RE: Response to Submissions and Amended Proposal Report - Powerhouse Parramatta State Significant Development SSD-10416

APPENDIX A – TECHNICAL FEEDBACK POWERHOUSE PARRAMATTA SSD-10416 (RESPONSE TO SUBMISSIONS AND AMENDED PROPOSAL REPORT)

Figure 4.03 - Terrace Level & River Plan

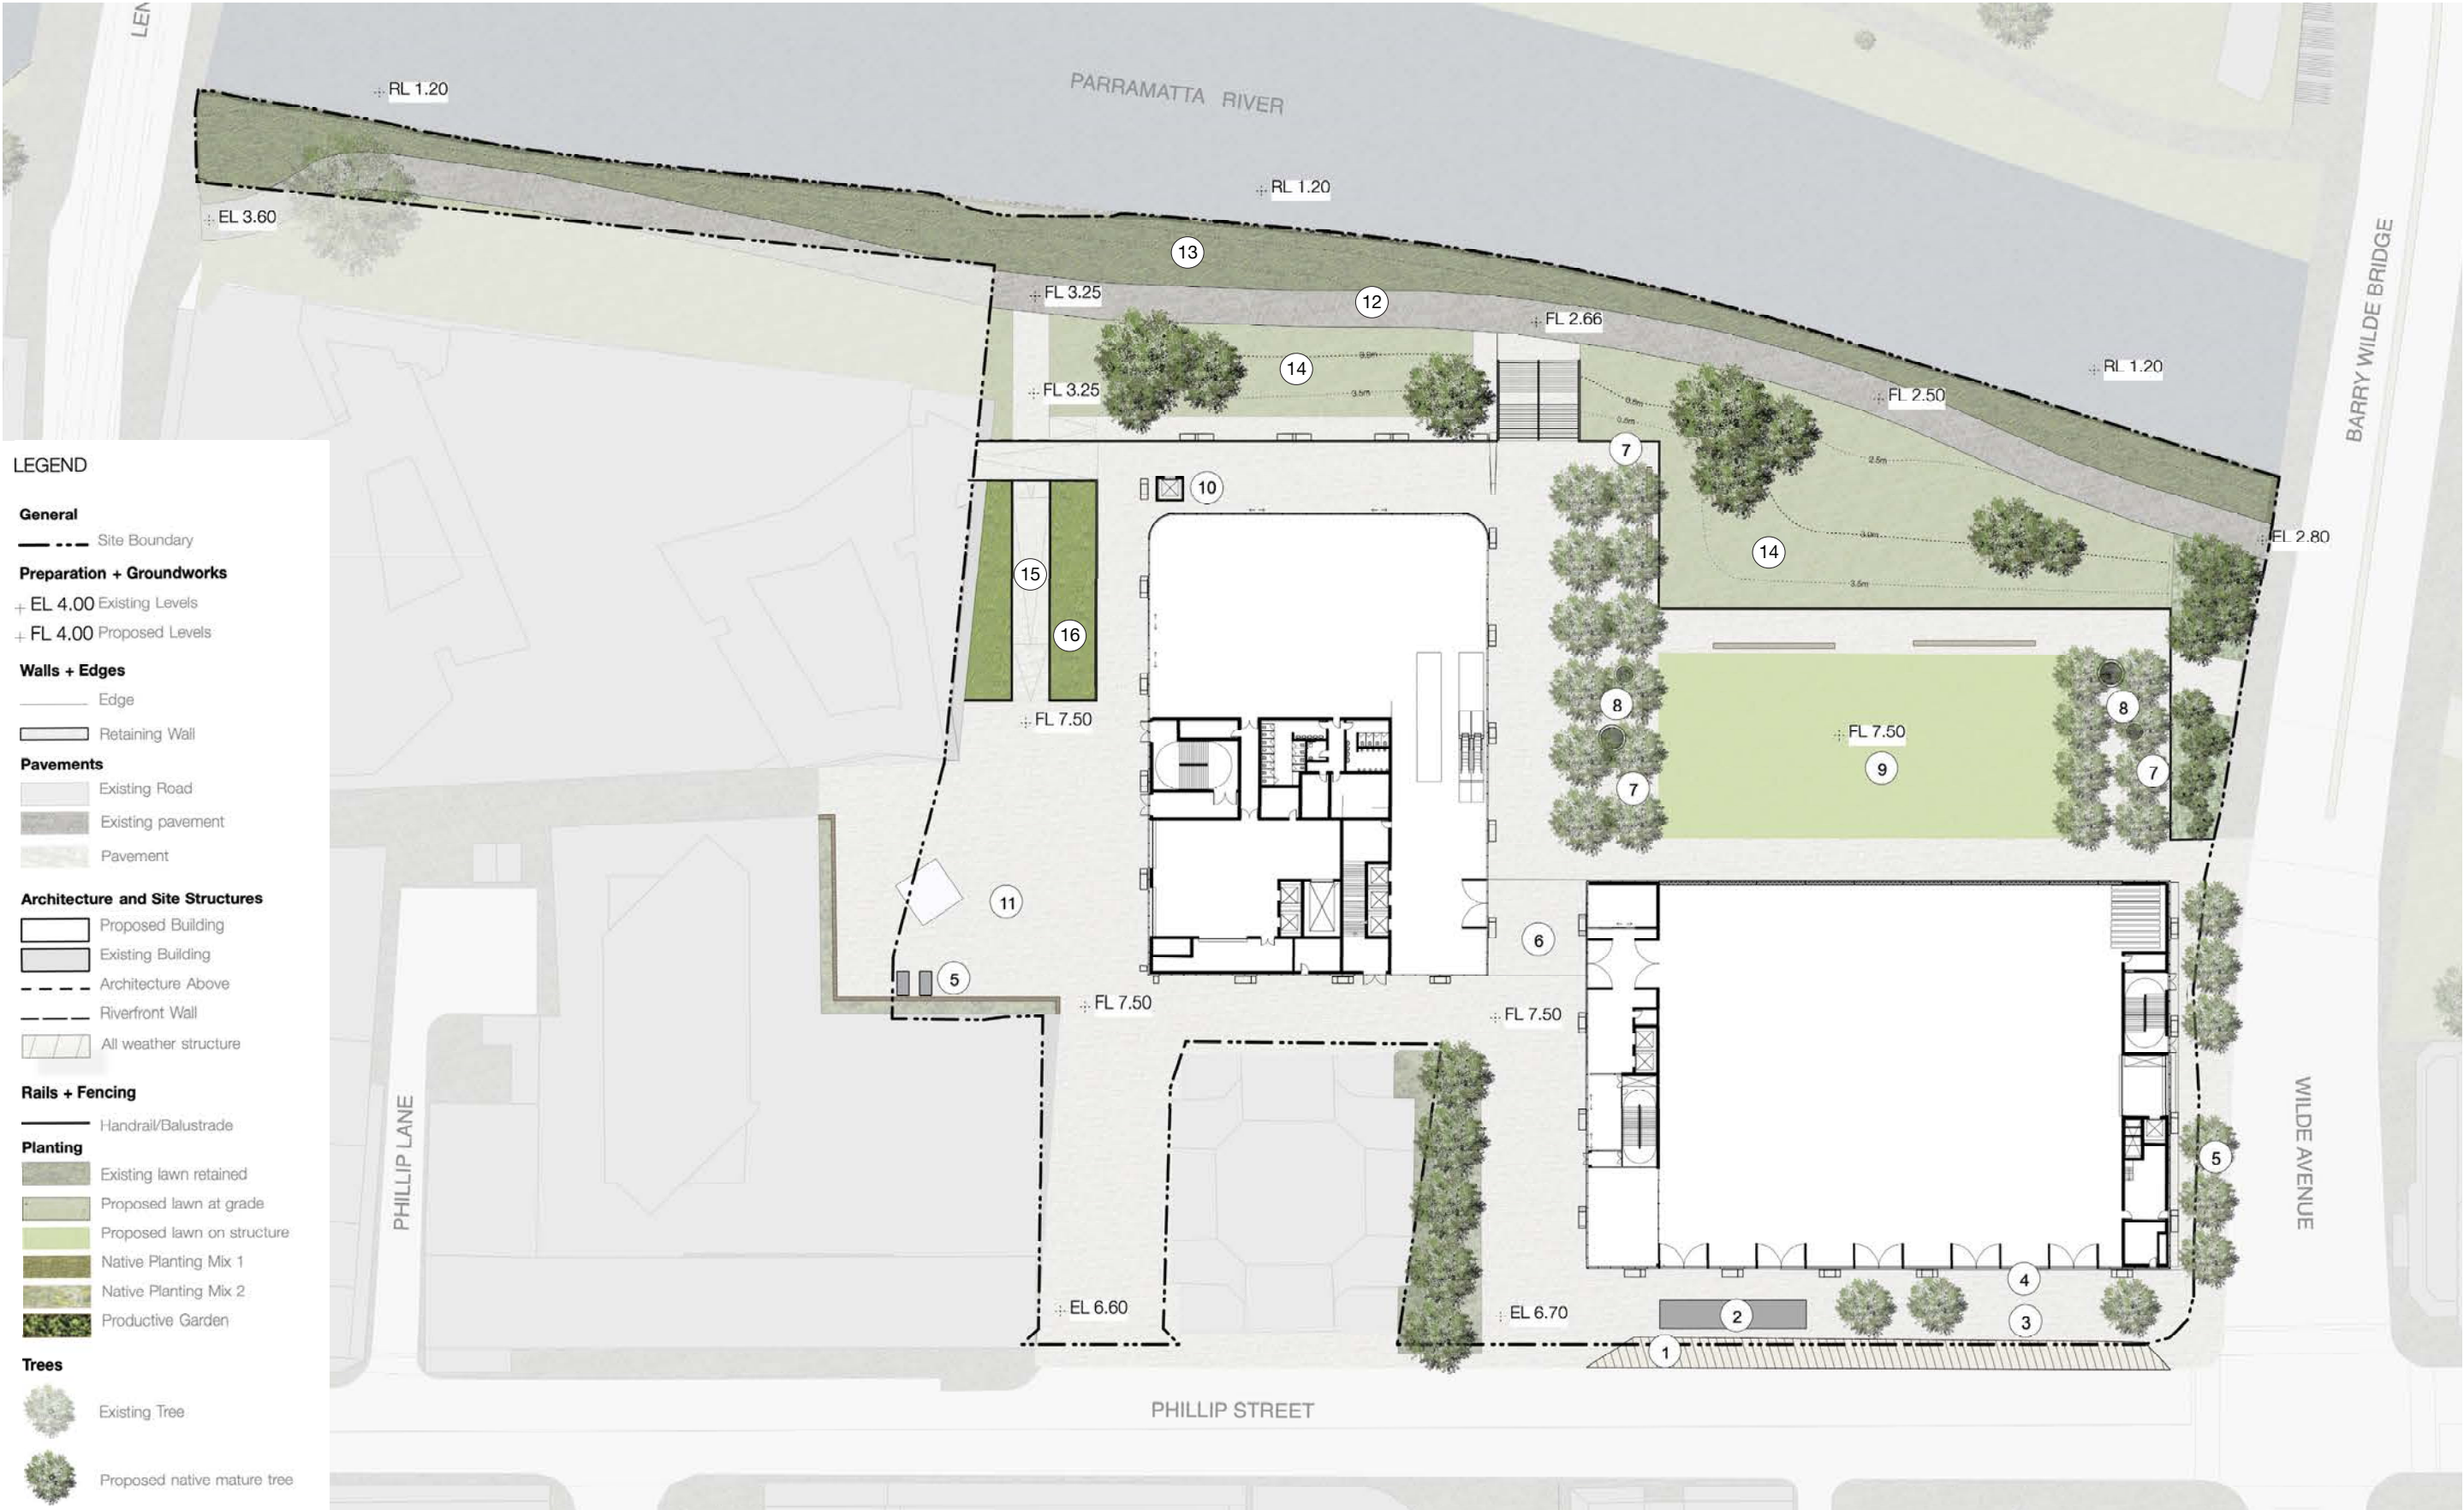
Whilst the public domain design has been amended, Council remains concerned that the Civic Link terminates in a stair, as opposed to the gentle ramp proposed in the competition winning design. This change in design response no longer achieves a fully public and universally accessible Civic Link connecting Parramatta Square to the River foreshore. The consequences of this are that Museum access from the foreshore is limited to mechanical means (a lift accessed from within the undercroft) and non-compliant access (shared with vehicles, loading and servicing) via Dirrabarri Lane.

A SECTION AA
Scale 1:200

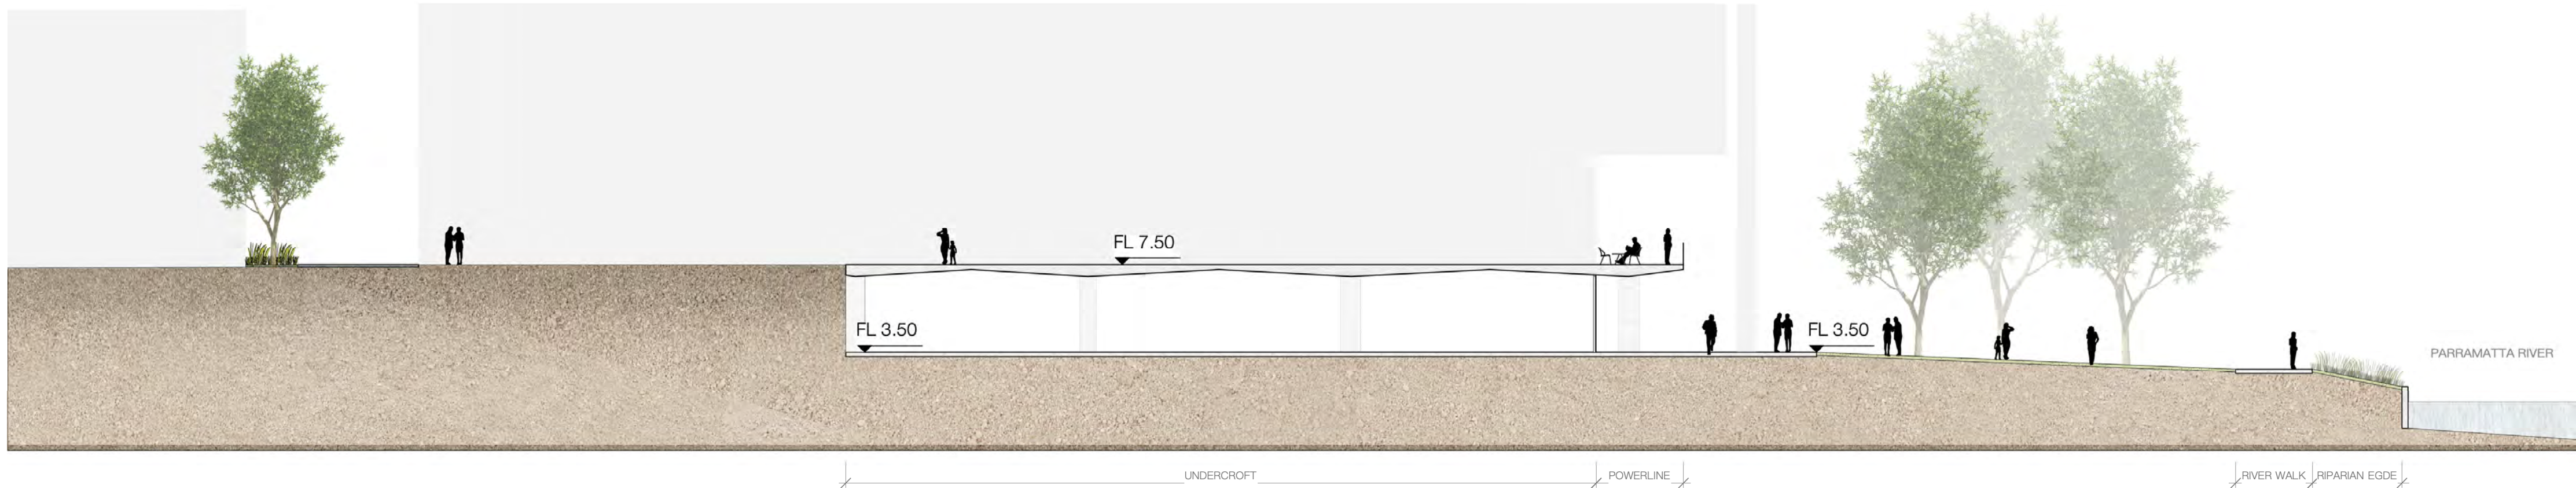
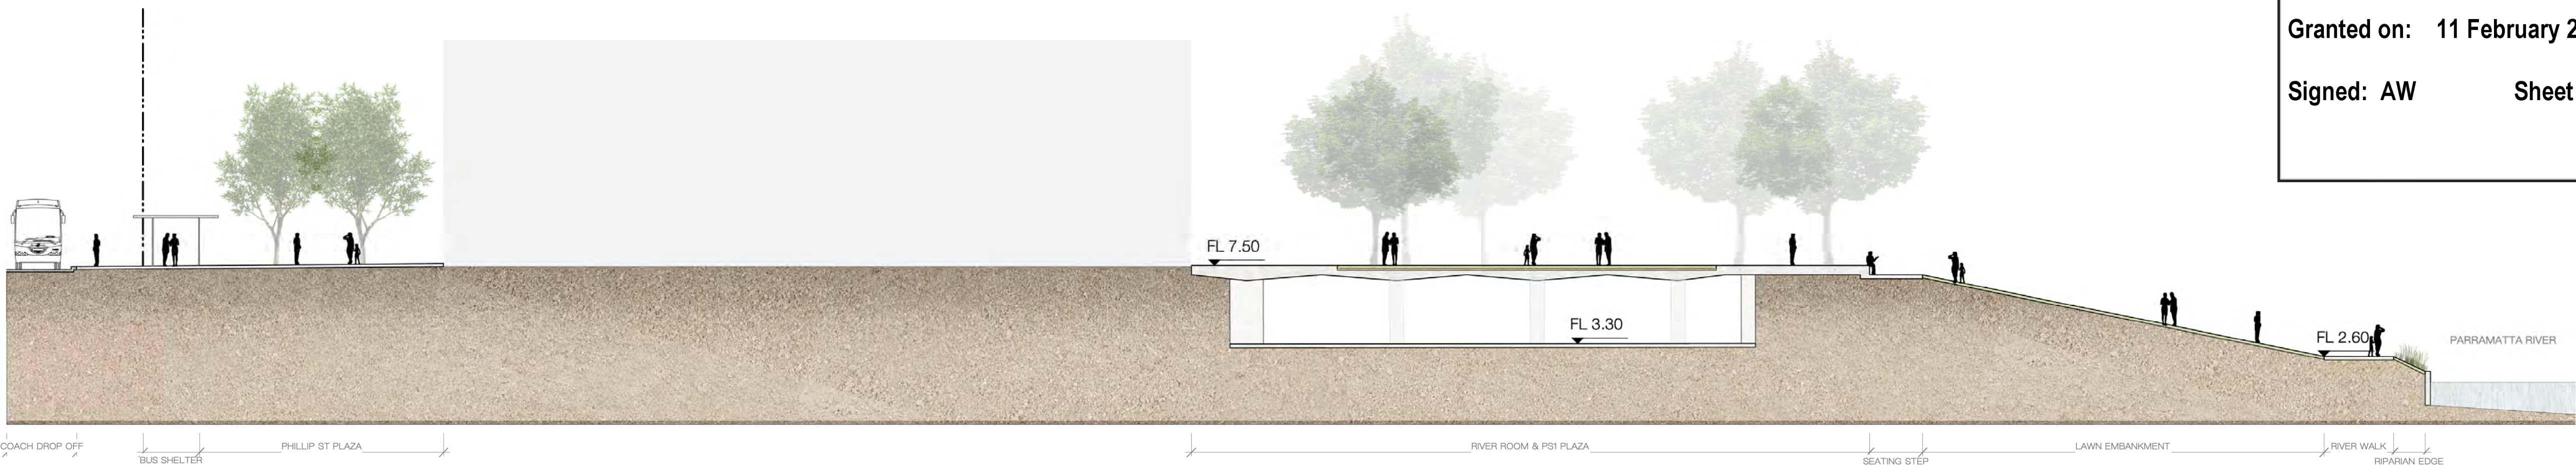
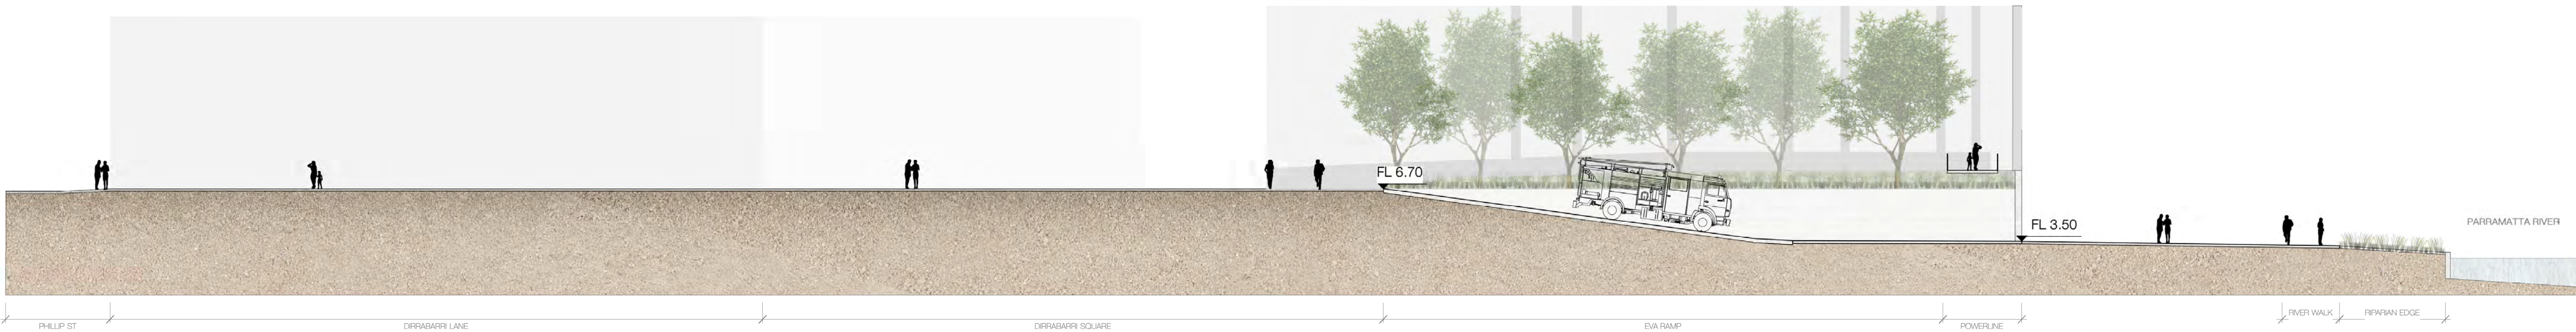
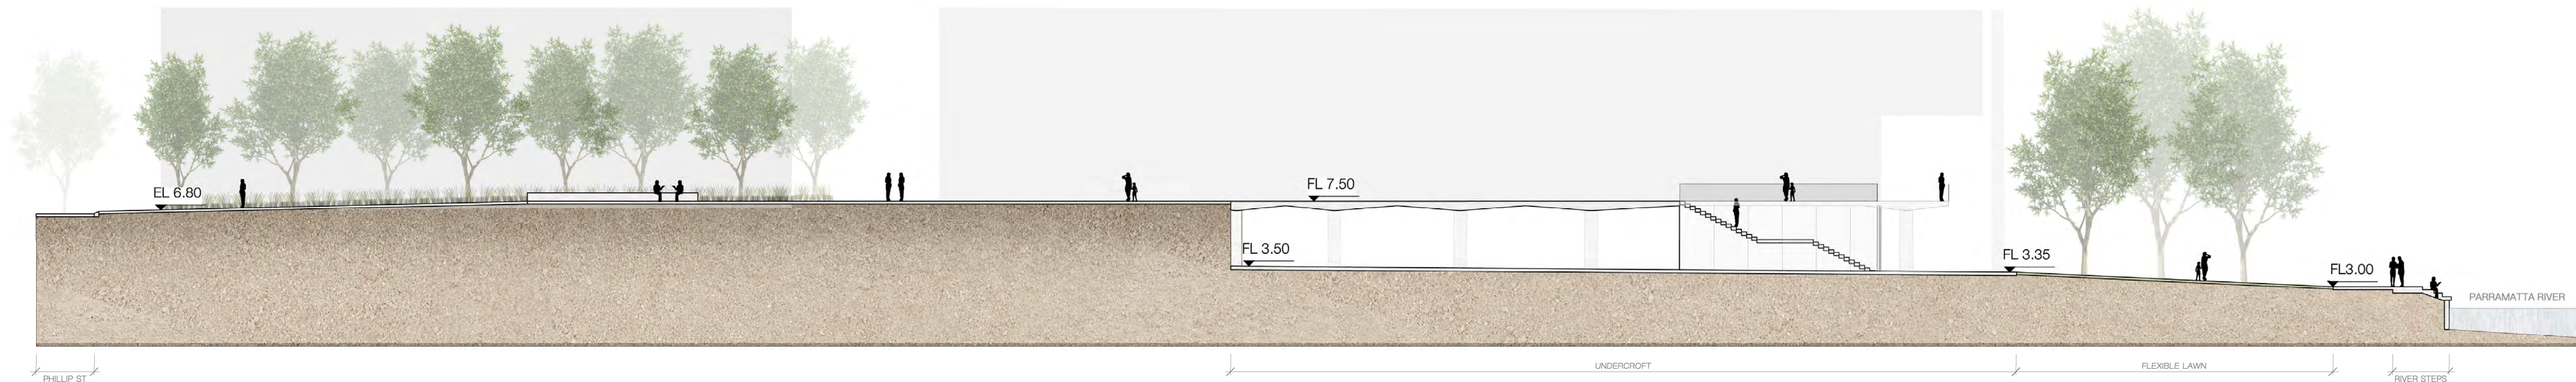
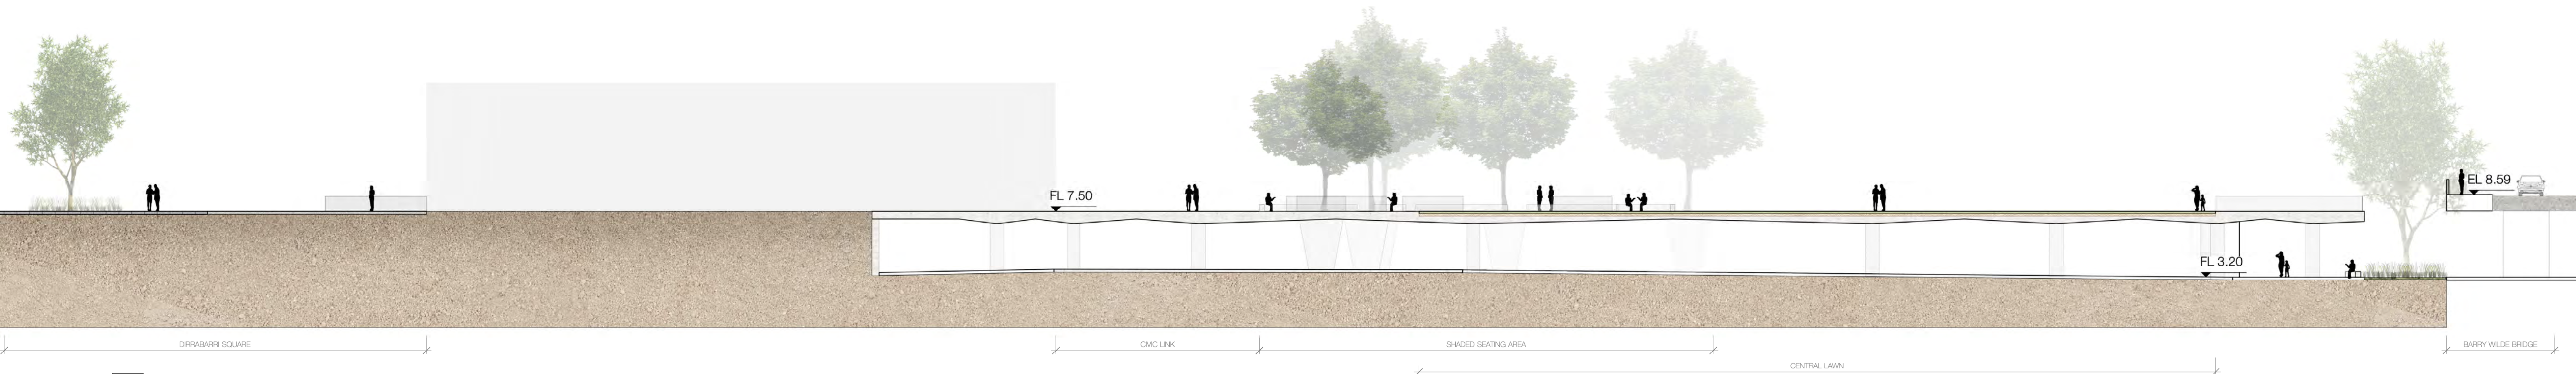
While Council acknowledges that the undercroft space will have limited access by the public through the erection of moveable screens managed by the Powerhouse, Council maintains its concerns regarding the suitability of the undercroft as a flood solution where the conveyance of floodwater through the undercroft also passes through proposed habitable floor space. This is due to the potential threat to life, property and critical building services in a flood event (including evacuation via a single, limited capacity lift, which provides critical access to mobility impaired). Council considers this to be in contradiction of the Floodplain Development Manual and NSW Flood Policy. This space will have a level floor and the 1% AEP (100 year) floodwaters will flow with substantial velocity 2-3m deep extending to the back wall of this structure.

In this regard, Council reiterates its earlier recommendation that the undercroft be removed from the design. It also recommends the undercroft be replaced with a suitable sloping riverbank section that may be a viable solution to manage the conveyance of floodwater. This would also have the added benefit of creating a more integrated foreshore landscape interface where the 'natural' sloping riverbank profiles that existed before the existing car park was originally constructed (and which appear to be still visible on site) could be considered as the baseline for predevelopment conveyance capacity and afflux considerations.

Related to the undercroft and flooding, is the public domain response. The proposal includes an extensive podium that acts as a cover to the undercroft, separating the museum from the river foreshore and dividing the space into two disconnected spaces. This results in a podium landscape which is constrained in its ability to deliver an integrated flood conveyance solution. Council understands that the purpose of the podium landscape relates to museum programming in the external space, including potential exclusive use periods with fencing and ticketing dividing the site.

If the undercroft was removed, Council sees an opportunity to redesign the interface between the buildings and the surrounding public space, replacing significant vertical transition with a sloped or terraced landscape form more reminiscent of the competition scheme. This approach is likely to improve connections between the Museum and river foreshore, and provides opportunities for a range of civic events more in keeping with River Square public space envisioned in Parramatta City River Strategy.
